# KITITAS COUNTY

**TO:** All Staff  
**FROM:** Public Works Plan Review Team  
**DATE:** August 5, 2025  
**SUBJECT:** SPF-25-00004 Fahlgren

SHEET 1 OF 2

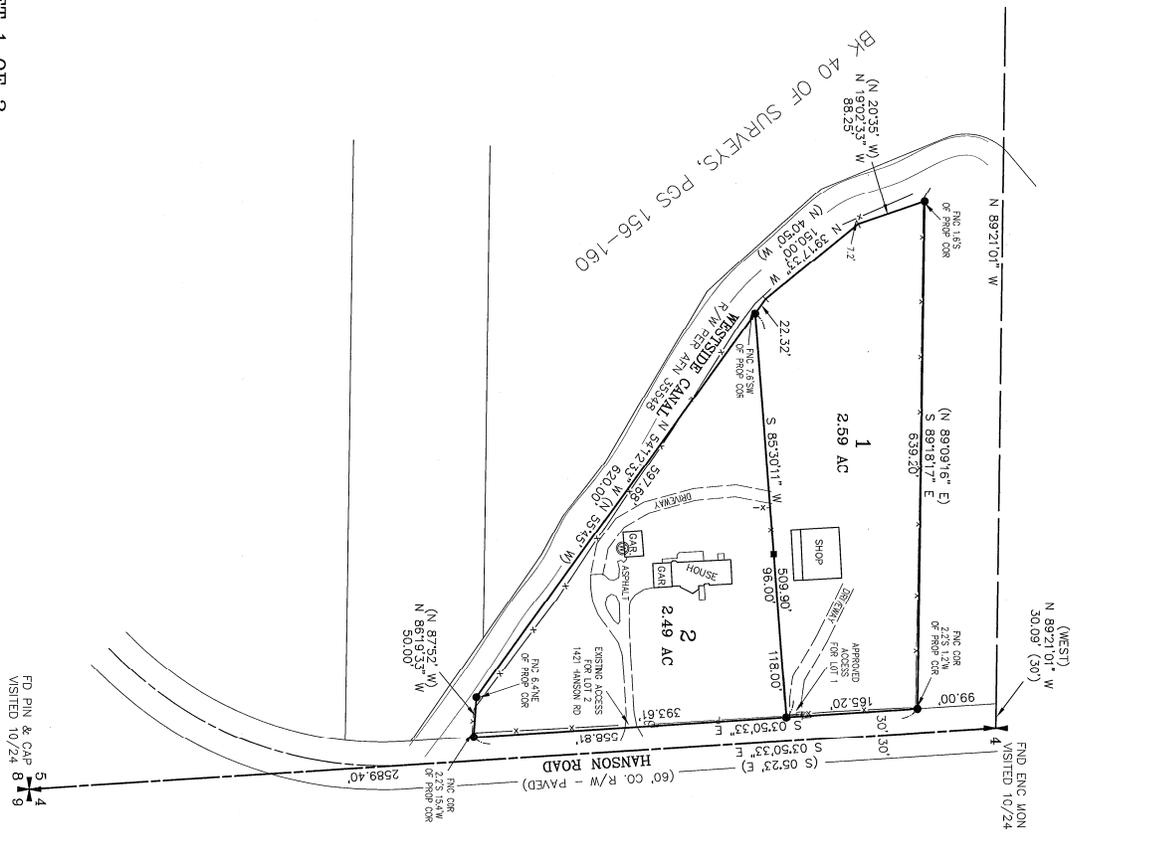
<b>ACCESS</b>	<ol style="list-style-type: none"> <li>1. Road Variance RV-25-00014 applies to newly created lot (LOT 2)</li> <li>2. An approved access permit shall be required from the Kittitas County Department of Public Works prior to creating any new driveway access or altering an existing access.</li> <li>3. Maintenance of driveway approaches shall be the responsibility of the owner whose property they serve. The County will not maintain accesses.</li> <li>4. Any further subdivision or lots to be served by proposed access may result in further access requirements. See Kittitas County Road Standards.</li> <li>5. In addition to the above-mentioned conditions, all applicable Kittitas County Road Standards apply to this proposal. Access is not guaranteed to any existing or created parcel on this application.</li> </ol> <p>OF NOTE: Please ensure that the new parcels created in this short plat are identified with the correct address upon final recording. (RC)</p>

<b>ENGINEERING</b>	Except as exempted in KCC 14.05.060, no grading or filling upon a site involving more than one hundred (100) cubic yards shall be performed without a grading permit from the County Engineer or Public Works designee (KCC 14.05.050). An application for grading in excess of five hundred (500) cubic yards shall be accompanied by an engineered grading plan (KCC 14.05.080). This grading plan will be under a joint review with the City of Ellensburg. (CBP)
<b>SURVEY</b>	<p>Please include offset distances between the fence and the property deed line.</p> <p>OF NOTE Due to the simple nature of this Short Plat, Lot closures are not needed, nor were they reviewed. (JT)</p>
<b>TRANSPORTATION CONCURRENCY</b>	No Comment.
<b>FLOOD</b>	No comments. (SC)
